TO: All Staff  
FROM: Public Works Plan Review Team  
DATE: November 1, 2021  
SUBJECT: BL-21-00025 PUD Bettas Rd

The Public Works Department has reviewed the Request for Boundary Line Adjustment Application.

RECORD OF SURVEY - BOUNDARY LINE ADJUSTMENT

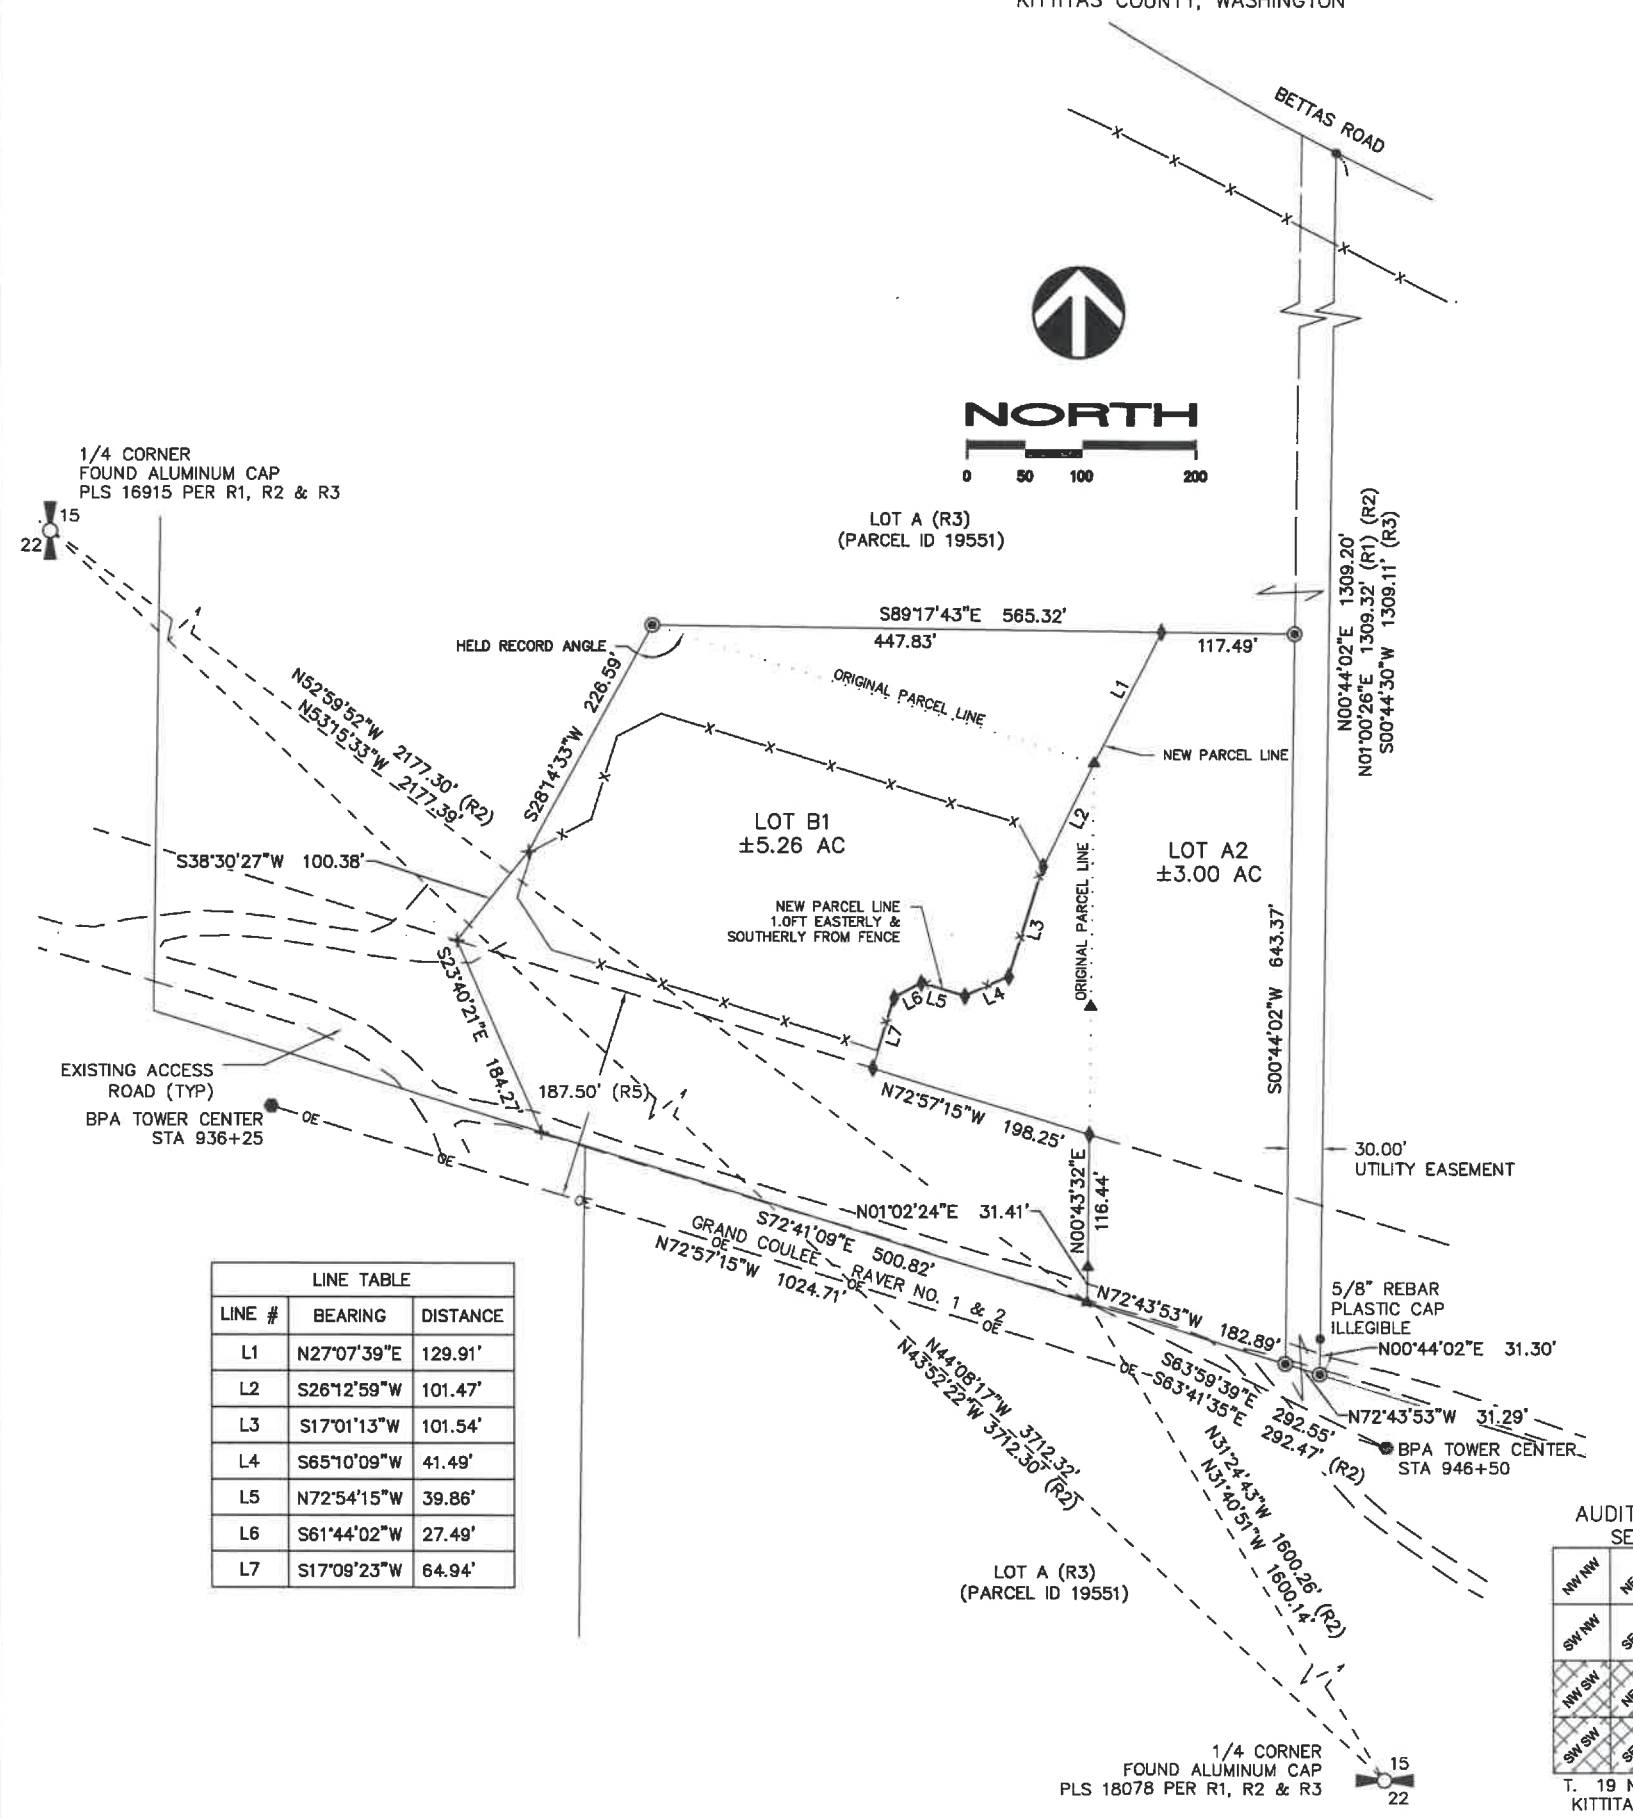
1. Reference 'R4' should be changed to Book 43 of Surveys, Page 211.
2. The 30' Utility easement located should include the Auditor's Recording Number. (Per SUR:43-211, this was created by a separate document)
